**Application: SSI 7485**

I write regarding the proposed modification to M4-M5 Link, Mod 2 The Crescent overpass and changes to pedestrian infrastructure in North Annandale, Rozelle and Rozelle Bay Foreshore area. *I object to the car overpass and to the relocation of the Greenlink and*

Figure 4-2 Pedestrian and cyclist bridge infrastructure options

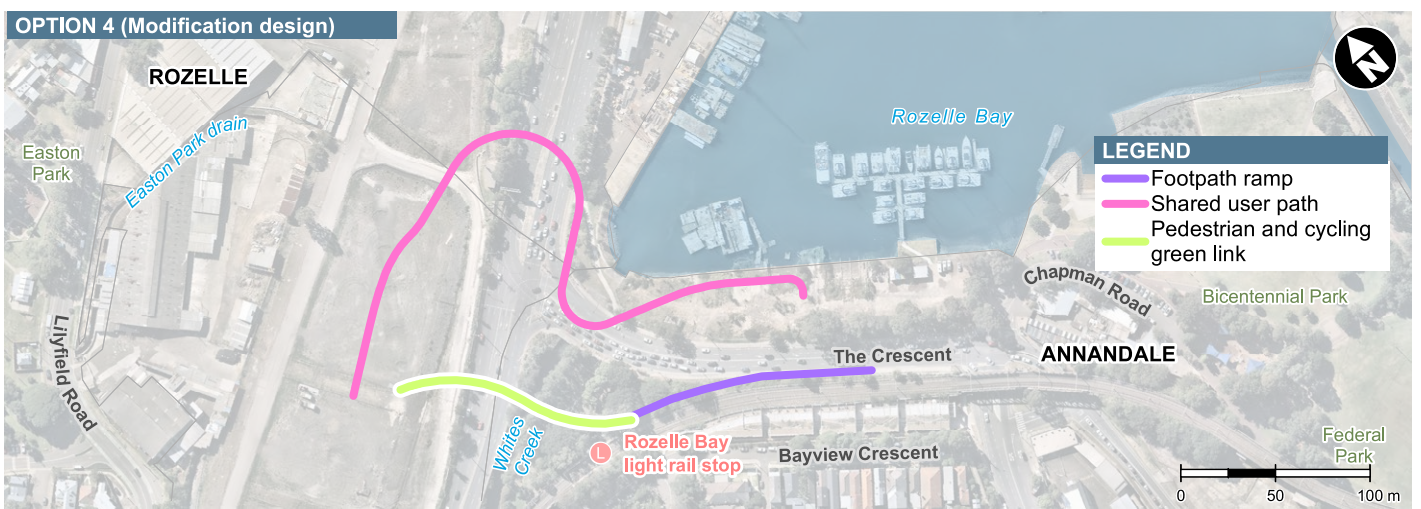
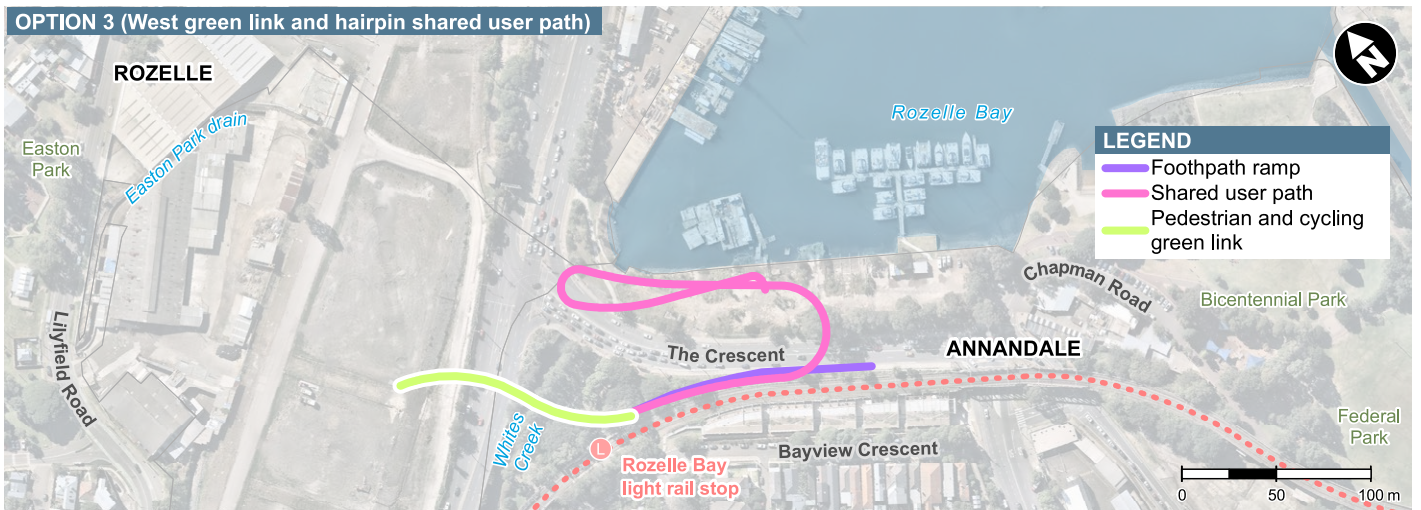
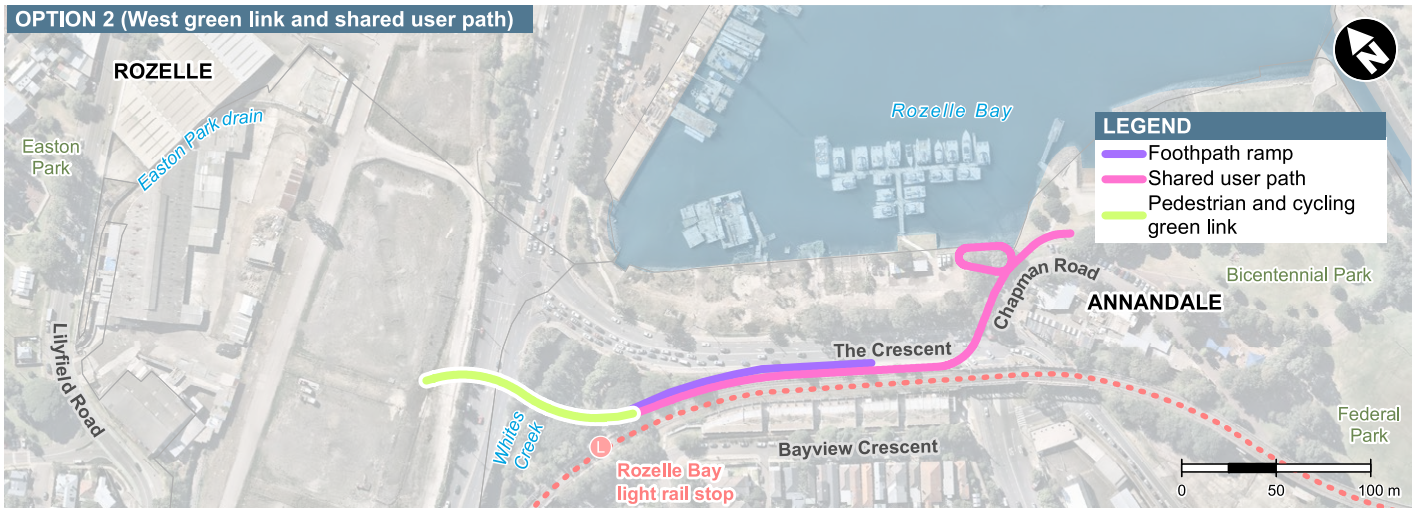
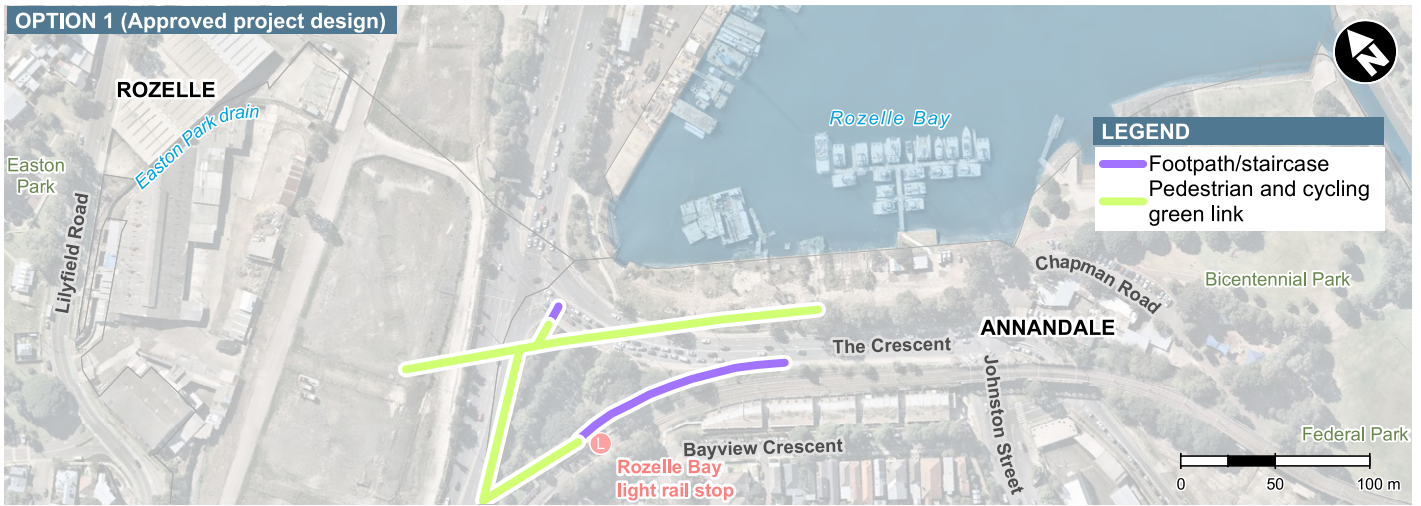
Furthermore I suggest you **revisit Option 2:**

You dismissed Option 2 as having a 'lack of passive surveillance from passing road users and nearby residences' yet I fail to see how the proposed route provides this or how a lack of passive surveillance is overcome in the currently proposed Greenlink. Pedestrians and cyclists will be well above the road, away from any residences, and it is unlikely vehicles will see the pathway clearly in the current Proposal.

Furthermore, the route of Option 2 is much closer to residences and other local businesses which may provide some surveillance. An alternate option to your Option 2, would be to provide an upper level greenlink, over the currently proposed footpath ramp, at a low level providing passive surveillance from passing road users, and some privacy to nearby residences. This Greenlink from the Light Rail stop to Bicentennial Park will be instrumental in providing a clear and accessible path to the proposed Ferry stop at Rozelle Bay. This in turn will ease Light Rail congestion from Rozelle Bay to the CBD and promotes use of public transport for the local community.

The other objection was the visual impact of the ramp/overpass close to the bay and park. I am sure professional urban designers will be able to create a suitable design to integrate the structure into the local area.
